ROAD SAFETY AUDIT  
STAGE 1

PROPOSED ACCESS AND PARKING AREA  
MEPAL CREMATORIUM  
A142 IRETON'S WAY  
MEPAL, ELY

REPORT REF: BN/CDS/20-102

Including Designer's Response  
27 July 2021

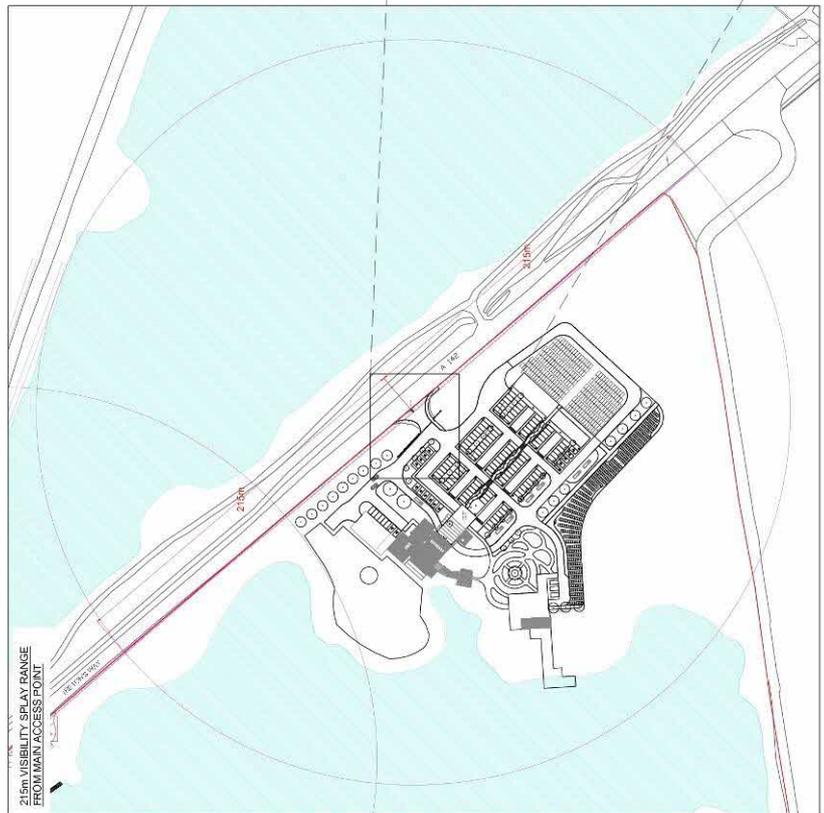
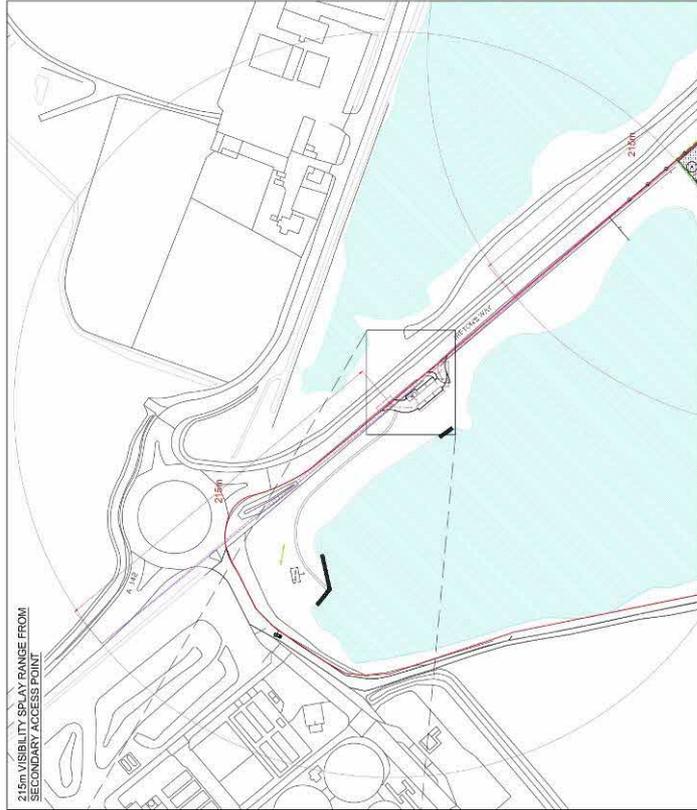
PROBLEM	
Location:	A – Site Access and Proposed Parking Area for Recreational Activities
Summary:	Existing vegetation may reduce visibility resulting in a driver pulling out of the access into the path of oncoming vehicles
<p>Whilst on site it was noted that there is a reasonable level of vegetation within the vicinity of both the existing access and the exit junction for the proposed parking area. Reduced visibility may result in a driver pulling out of the access into the path of an oncoming vehicle.</p>	
RECOMMENDATION	
<p>It is recommended that visibility splays are introduced to the drawings with stopping sight distance appropriate with the speed limit on the A142 Ireton's Way.</p> <p>It is also recommended that all vegetation is cleared from within the visibility splays.</p>	
DESIGNER'S RESPONSE	
<p>The recommendation is accepted and appropriate visibility splays will be provided and maintained.</p>

PROBLEM	
Location:	B – Proposed Parking Area for Recreational Activities
Summary:	Potential obstruction of the A142 Ireton's Way resulting in rear end shunts
<p>The Audit Team is concerned that there may be insufficient space for a driver to completely enter the parking area when another drivers is exiting a parking space resulting in the potential for a vehicle to overhang onto the main A142 Ireton's Way and potential rear end shunts.</p>	
RECOMMENDATION	
<p>It is recommended that further information regarding this usage of this area is provided to the Audit Team at Stage 2 Road Safety Audit.</p> <p>It is recommended that Auto Tracking is undertaken to establish the ease as to which a driver can enter the parking area whilst another vehicle is exiting a parking space.</p>	
DESIGNER'S RESPONSE	
<p>This recommendation is accepted and related swept path analyses have now been undertaken. Further details will also be provided for the Stage 2 Road Safety Audit as required by the Audit Team.</p>

PROBLEM	
Location:	C - Access/Exit to the Crematorium
Summary:	Increased risk of collisions involving higher speeds and right turn manoeuvre.
<p>The Audit Team are concerned that to join the flow of traffic on the A142 Ireton's Way drivers looking to travel southbound and exit right out of the Crematorium put themselves at risk of strike by oncoming vehicles. This is a particular issue as the posted speed limit on the A142 Ireton's Way is 60mph and the higher approach speeds may make exiting the junction difficult and encourage drivers to seek gaps in the traffic. This will be further exacerbated by high levels of vehicles attempting to exit the junction at the same time resulting in impatient drivers.</p> <p>NB: At the junction for the Mepal Quarry (south of the main entrance to the crematorium) there is a sign stating 'That all vehicles must turn left by order of Cambridge shire Highways'. It is unclear whether this sign is legally binding however it does highlight this as a potential issue on other junctions along this stretch of the A142 Ireton's Way.</p>

PROBLEM	
Location:	D – Exit from Proposed Parking Area for Recreational Activities
Summary:	Increased risk of collisions involving higher speeds and right turn manoeuvre.
<p>The Audit Team are concerned that to join the flow of traffic on the A142 Ireton's Way drivers looking to travel southbound and exit right out of the parking area put themselves at risk of strike by oncoming vehicles. This is a particular issue as the posted speed limit on the A142 Ireton's Way is 60mph and the higher approach speeds may make exiting the junction difficult and encourage drivers to seek gaps in the traffic. This will be further exacerbated by proximity of the roundabout and the likelihood that drivers exiting the roundabout and entering the A142 Ireton's Way will be increasing their speed.</p>	
RECOMMENDATION	
It is recommended that a 'No Right Turn' order is introduced at this location.	
DESIGNER'S RESPONSE

PROBLEM	
Location:	All approaches
Summary:	Increased risk of collisions due to reduced awareness and higher approach speeds.
<p>The Audit Team are concerned that the awareness of this access will be reduced as the Mepal Outdoor Centre has been closed for some time. Approaching drivers will not expect drivers to be exiting the junction and may approach the access at speed resulting in the potential for conflict is a driver exiting the junction does so unexpectedly.</p>	
RECOMMENDATION	
<p>It is recommended that on construction temporary 'New Road Layout' signs are introduced to highlight the changes.</p> <p>It is also recommended that permanent 'Advanced Warning' signage are introduced on both approaches to highlight the increased movement into and out of the junction.</p>	
DESIGNER'S RESPONSE	
<p>The recommendation is accepted and detailed traffic signing proposals will be drawn up at the detailed design stage.</p>

RECOMMENDATION	
It is recommended that a 'No Right Turn' order is introduced at this location.	
DESIGNER'S RESPONSE	
The recommendation is accepted. Following discussion with the Highway Authority, it has been agreed that a 'Right Turn Prohibition' will be introduced at the exit from the Crematorium site, along with a new splitter island and associated signing.

<p>The recommendation has been discussed with the Highway Authority. However, it was agreed that such a measure would not be necessary, as the physical layout at this location would naturally encourage motorists to turn left, at a point where they will be able to see the nearby roundabout (where they will have the option to undertake a 'U-Turn'). It was also agreed that there is less risk associated with a right turn at this location, when compared with turning right from the Crematorium (and across the right turn ghost island).</p>
